27 August 2014

File No: R/2008/1/A  
Our Ref: 2014/389051

**RE: Modification Request for University of Sydney Abercrombie Precinct  
Redevelopment (MP07\_0158 MOD 5) – Student Accommodation Building**

02 INDICATIVE DESIGN INTENT
SCALE 1:20 @ A1

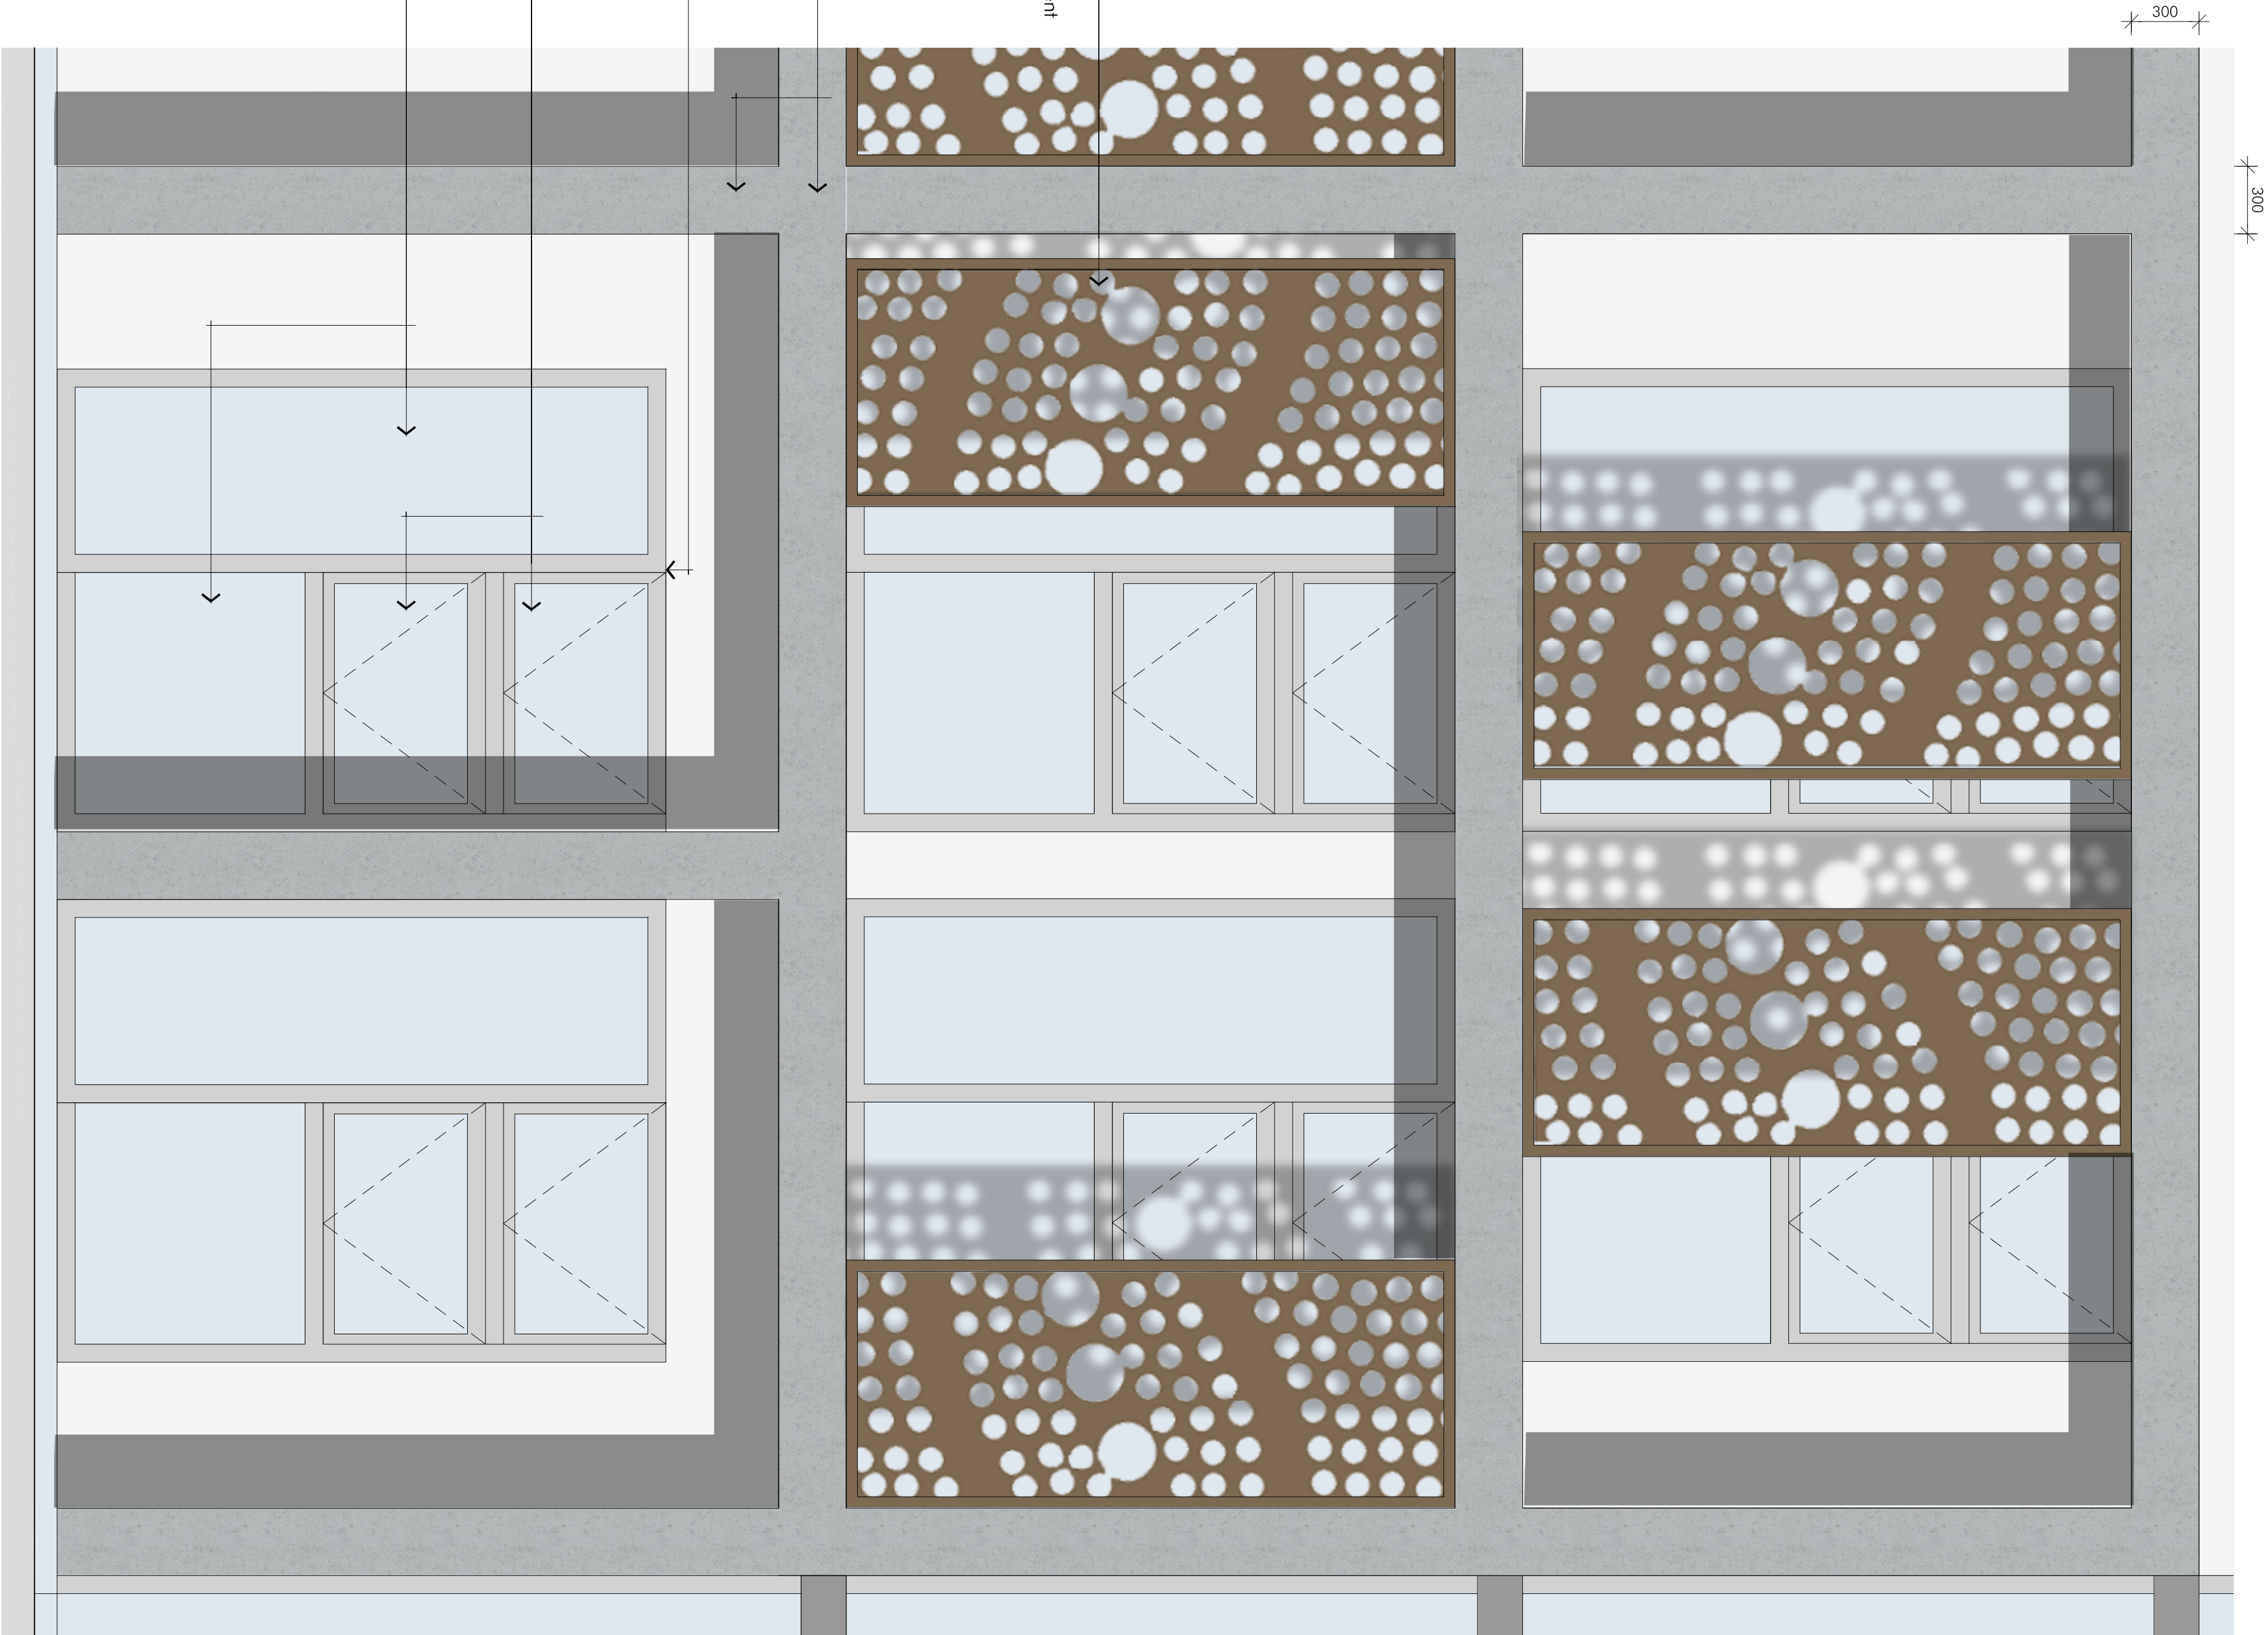
The modified design for the screens is considered less vibrant/striking than the original design and the finely cut design may tend to merge and be less distinguishable. However, no significant objection is raised to the design change.

It is recommended that the copper colour of the screens be maintained.

Level Roof
Project Number: 4001
Drawing Number: NTA-ASA-ARC-DWG-117
Scale: 1:100
Issue: K

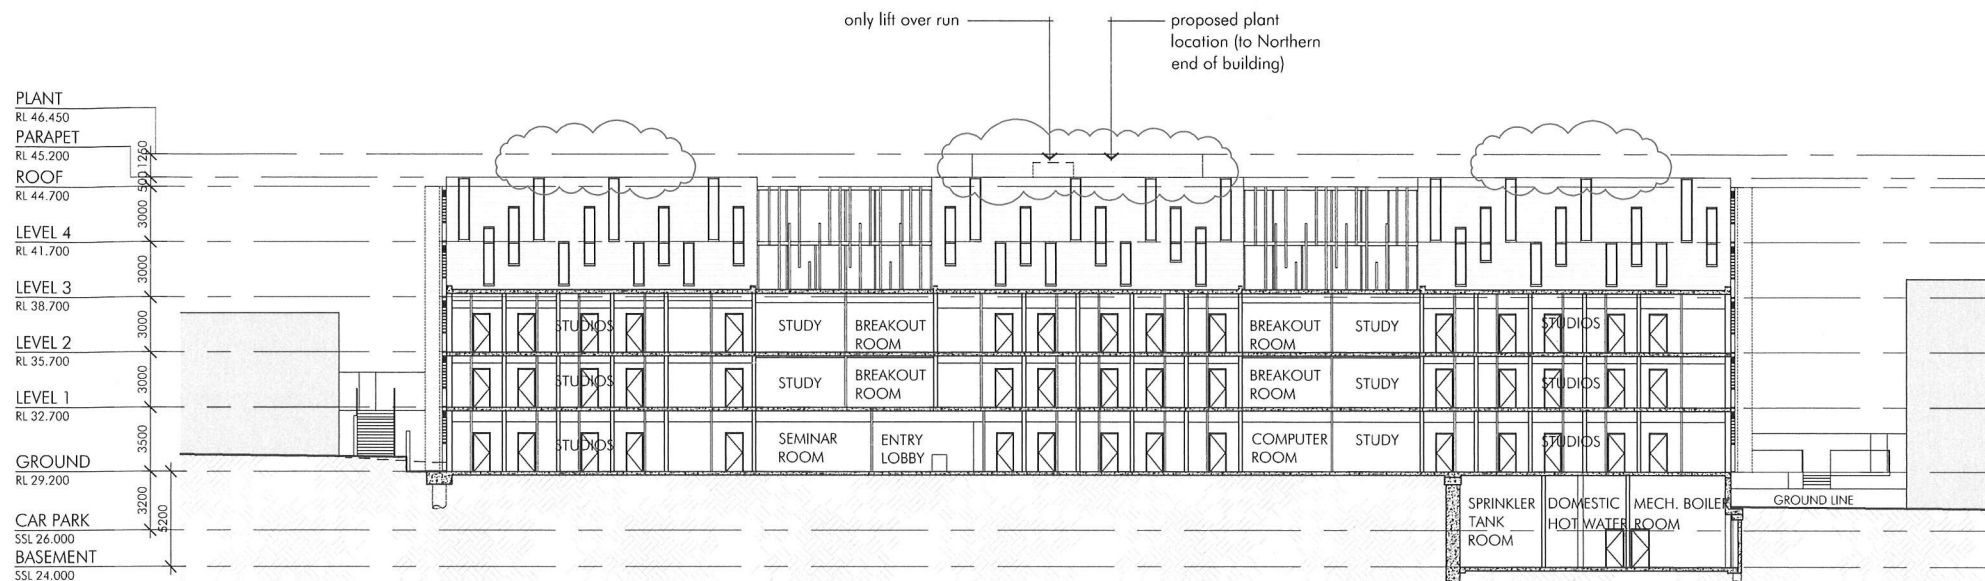
To achieve the 2030 target, the City actively promotes the use of renewable energy sources and supports the proposed inclusion of both the photo voltaic panels and solar hot water panels on the upper roof top elements of the student accommodation building.

The small parapet, the setback of the panels from the parapet edge, and the mounting height of the panels depicted on the plans will ensure that they are not readily visible from surrounding areas, nor cause adverse glare or reflectively effects.

The modification and consolidation of plant towards the northern end of the central rooftop tower element of the building is a distinct improvement on the previous three enclosures approved for plant, and is supported.
